BALDERSTONE
PARISH
COUNCIL

Re: 3/12/0269 Office Development at Myerscough Road, Mellor Brook

campbell driverpartners
 architects designers surv
 client: leehand properties ltd
 project: office development
 A59 Mellor Brook
 sheet: site plan

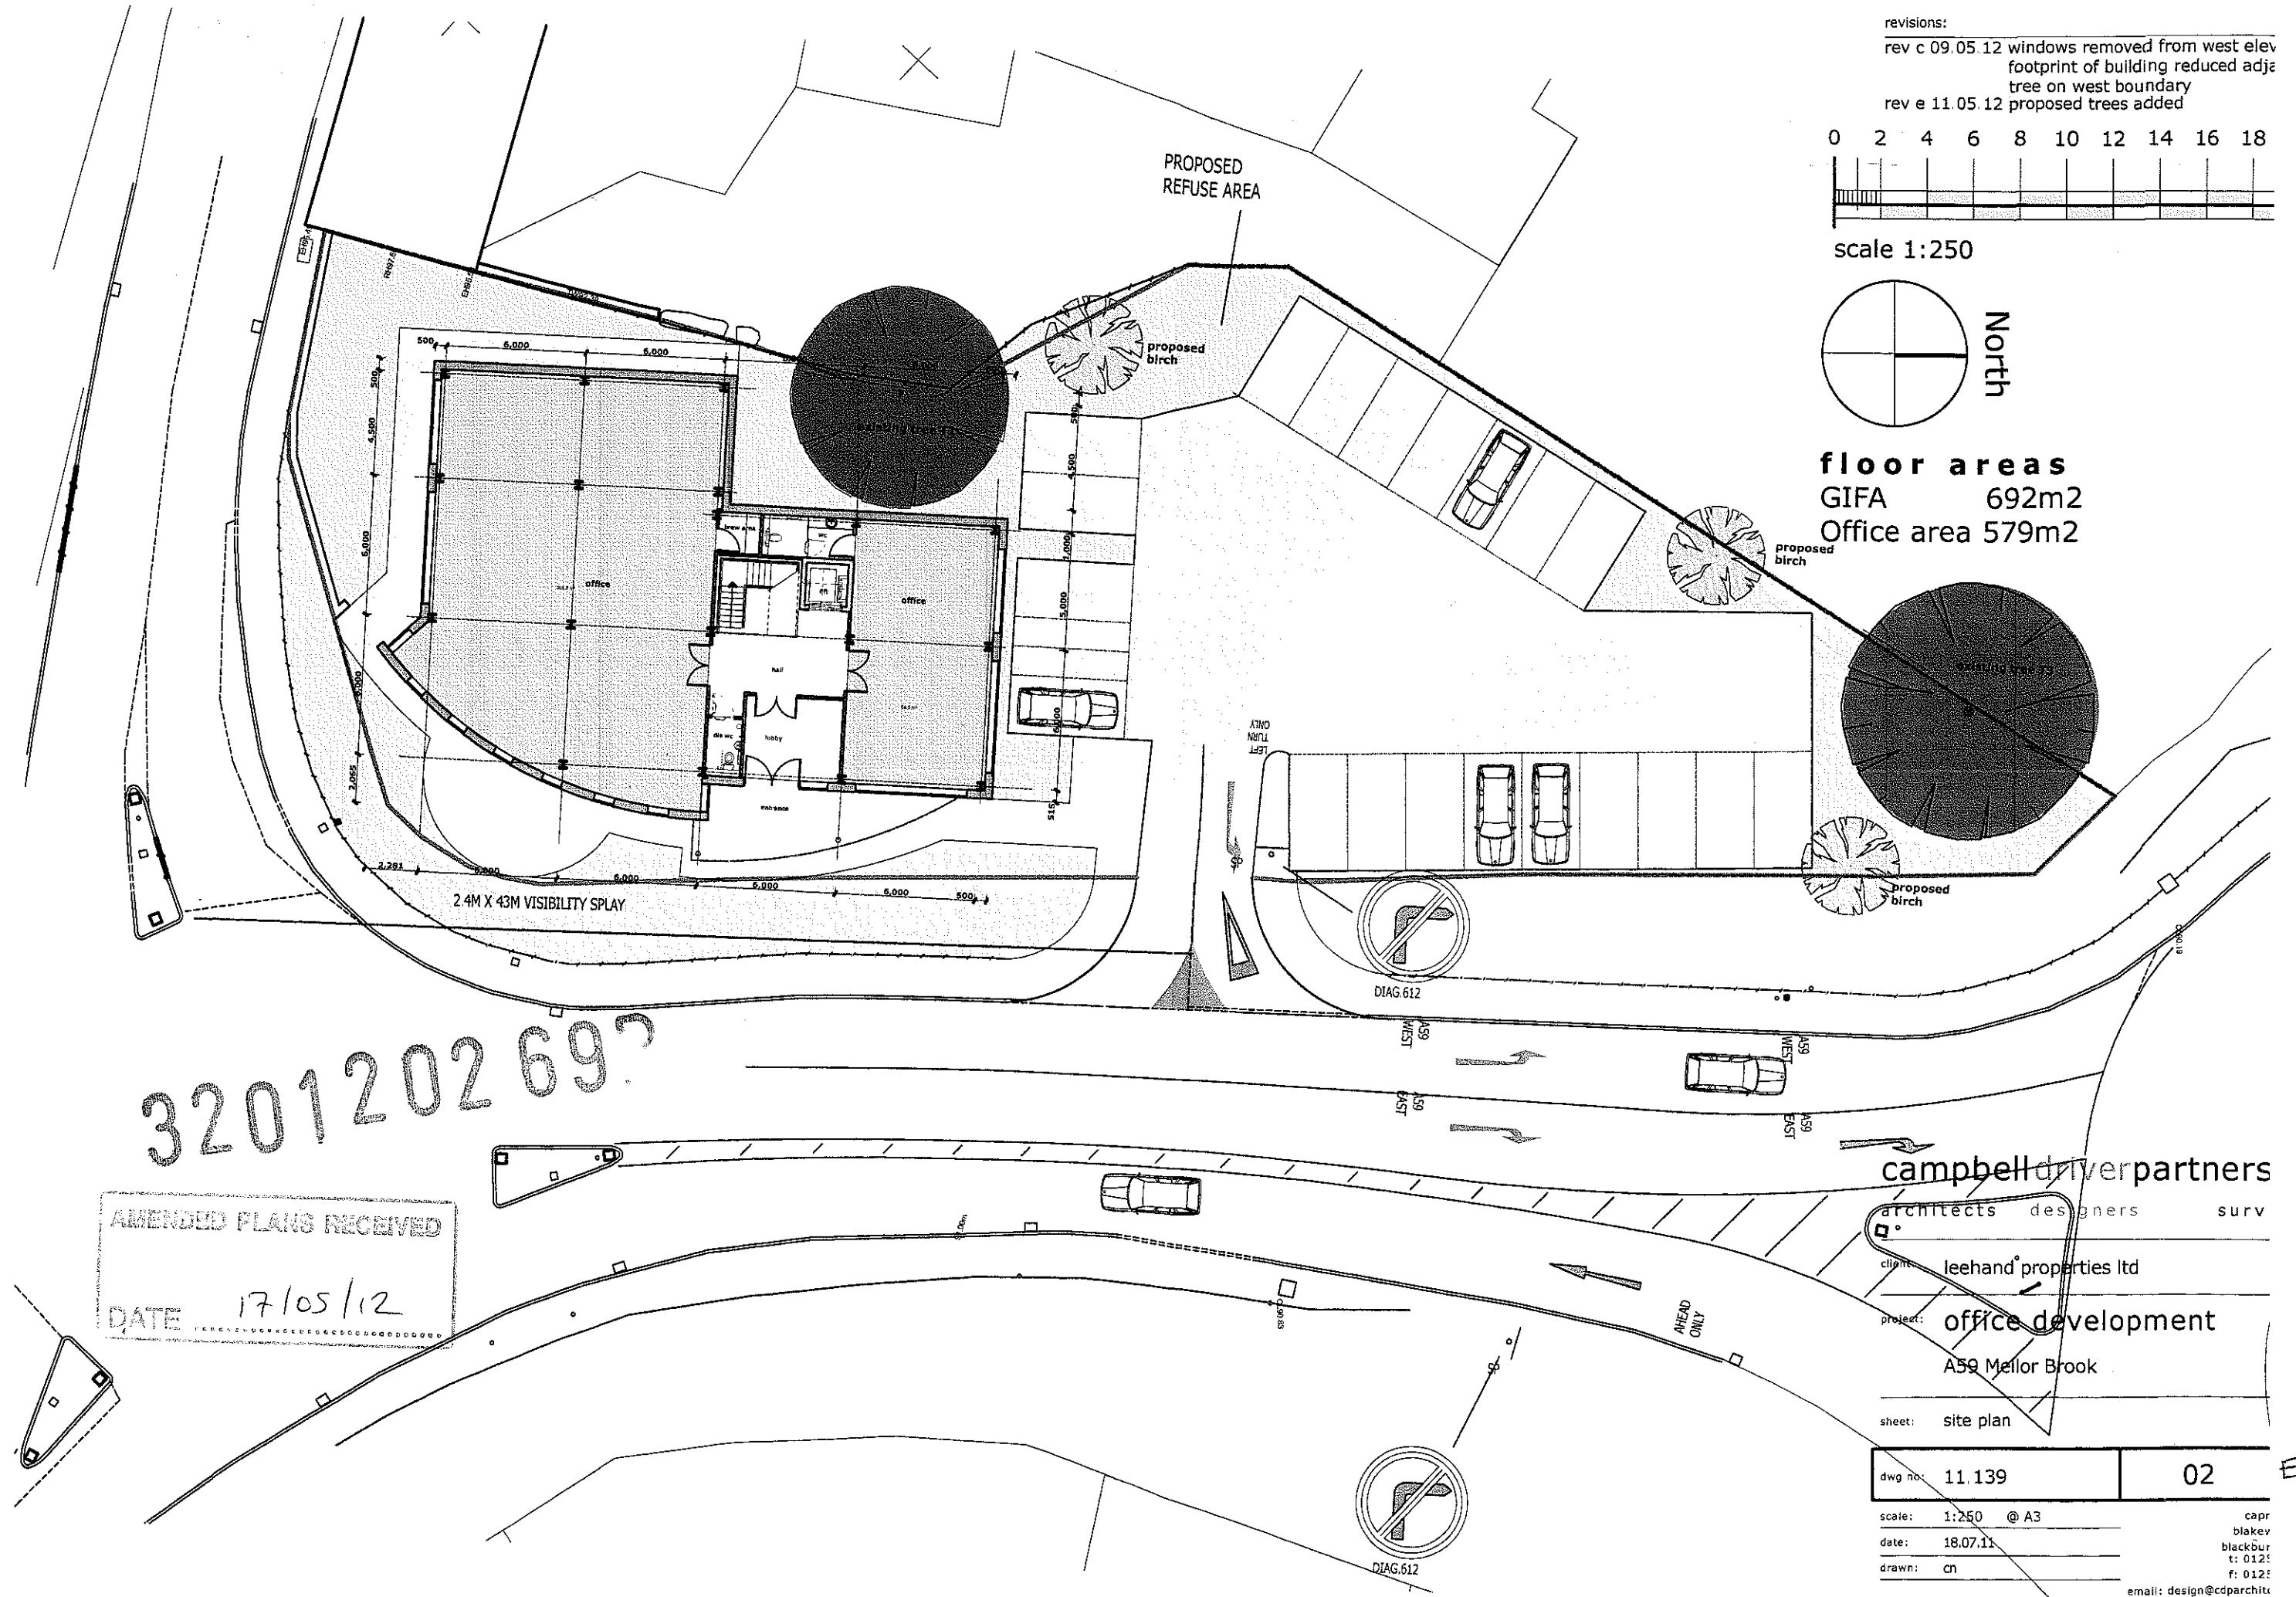
Although Council does not object to the application, we are of the opinion that the entrance to the Car Park is gated. This is for obvious security reasons. It would also be in accordance with the other buildings in the vicinity
